SSD-11606719 – DADEC Throughput Increase – EPA Response to Addendum Amendment and Submissions Report

Thank you for the referral to the Environmental Protection Authority (EPA) requesting review and advice on the *Eastern Creek REP Throughput Increase Addendum Amendment and Submissions Report* for the Eastern Creek Recycling Ecology Park, operated by Dial-A-Dump (EC) (Proponent), and located at 1 Kangaroo Avenue, Eastern Creek (Premises).

ATTACHMENT A

TITLE
SITE WORKSHOP

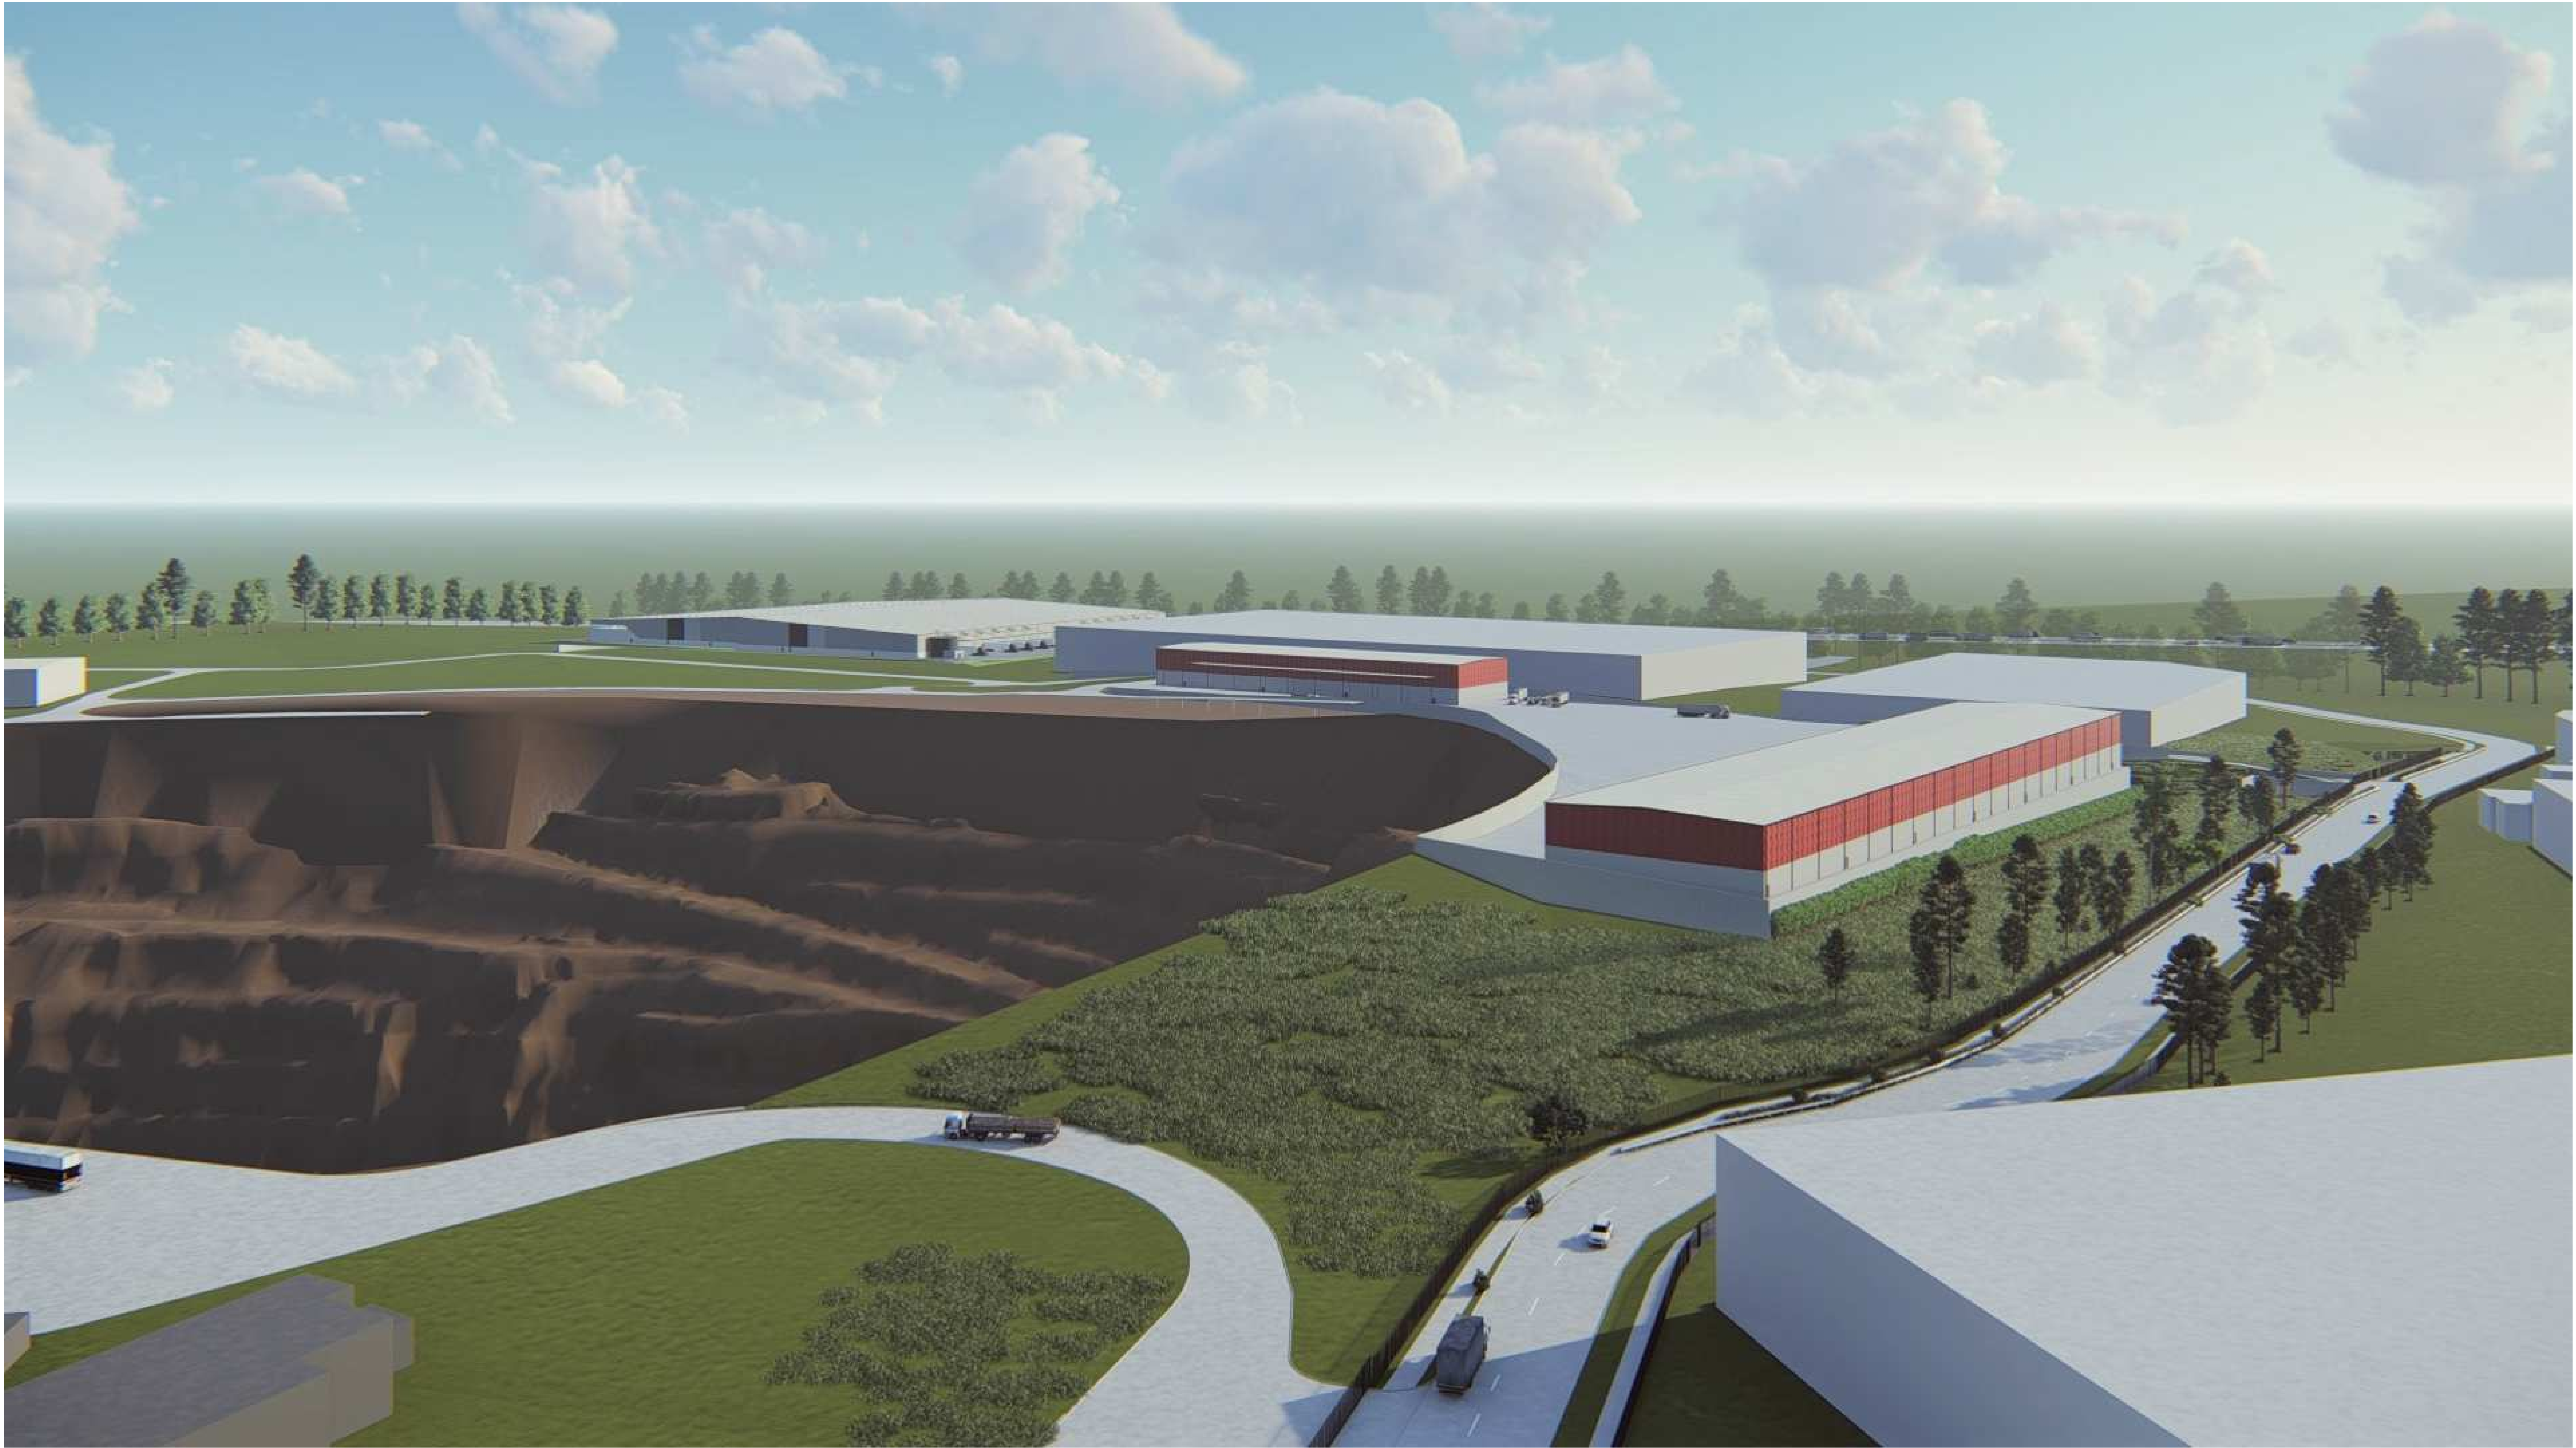
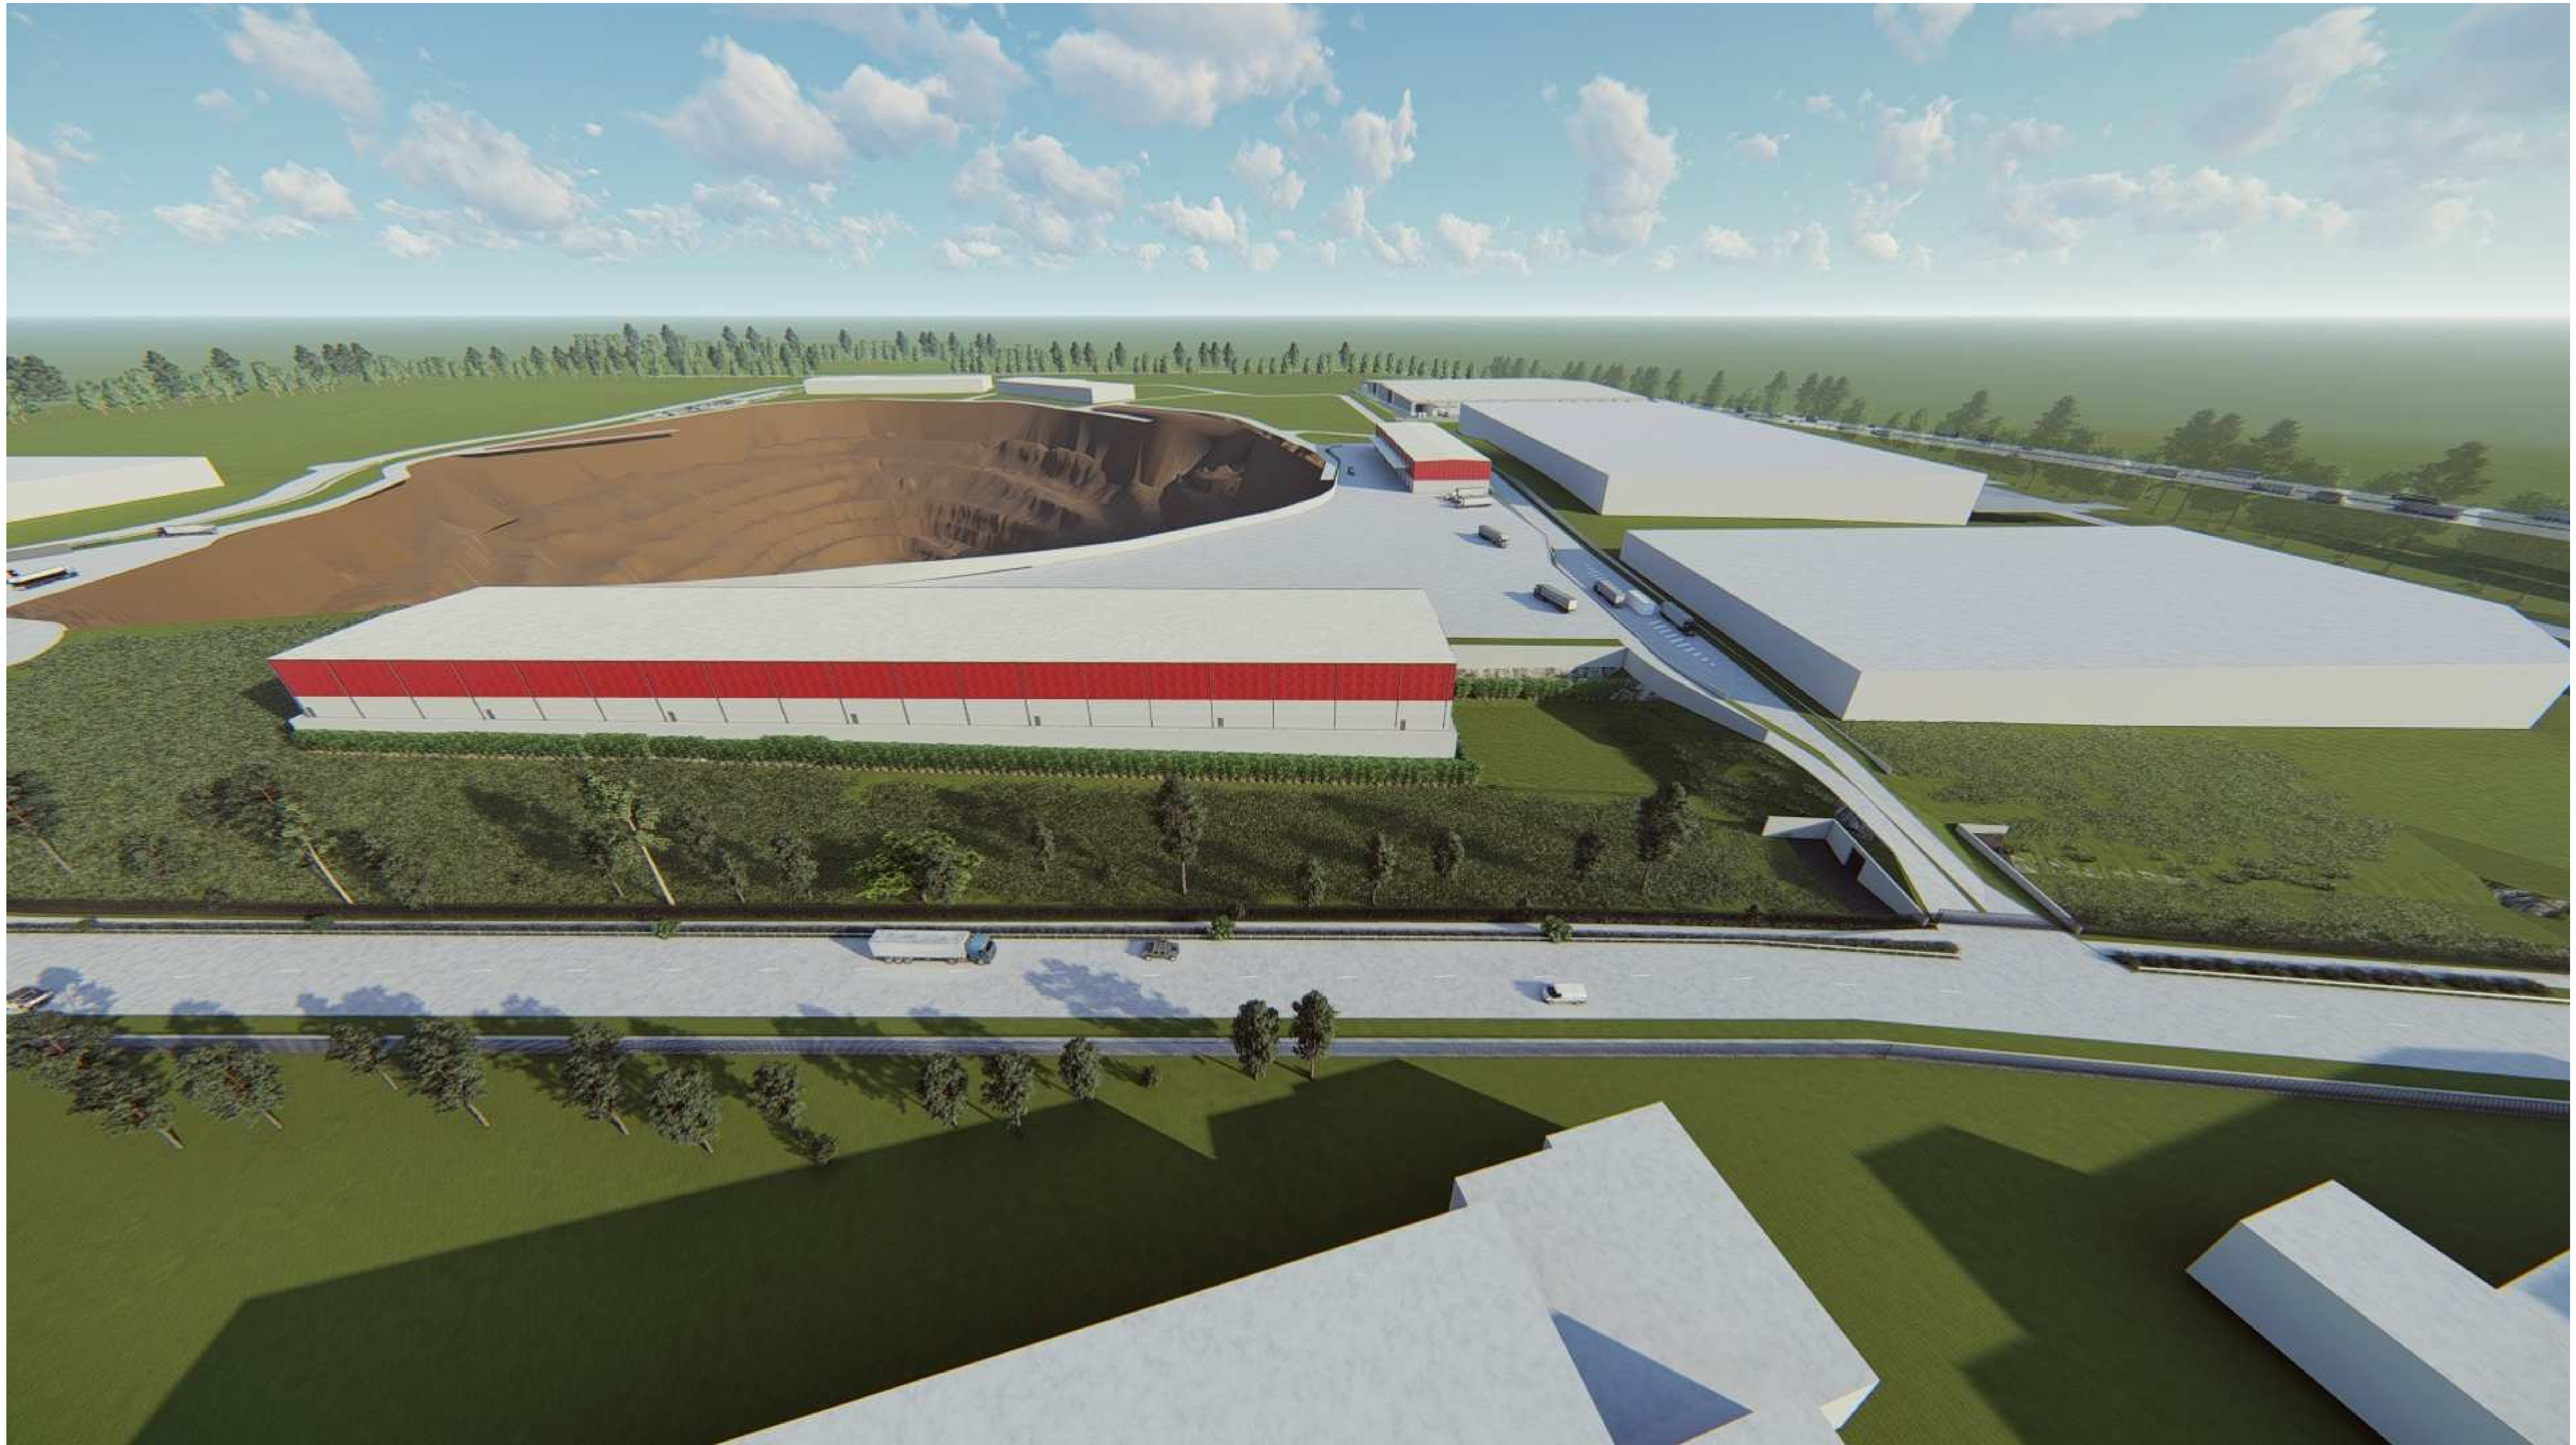
In Appendix A of the AASR, the Proponent provides inconsistent operating hours for the Site Workshop and Maintenance and Manufacturing Workshop. That is, the operating hours are proposed to be 12 hours per day between 6am and 6pm, consistent within existing approved hours of operation for the Eastern Creek REP. However, in Table 1-12 these hours are described as:

Monday – Friday 6:00am to 6:00pm
Saturday Sunday and Public Holidays - 5:00am to 9:00pm

The revised NVIA assumed the Site Workshop and the Maintenance and Manufacturing Workshop would be operational from 6am – 6pm, each day (including weekends and public holidays). The EPA recommend that should the proposal be approved, it be conditioned to include hours of operation for the Site Workshop and the Maintenance and Manufacturing Workshop accordingly.

The Site Workshop and the Maintenance and Manufacturing Workshop operating hours are 6am – 6pm, each day.
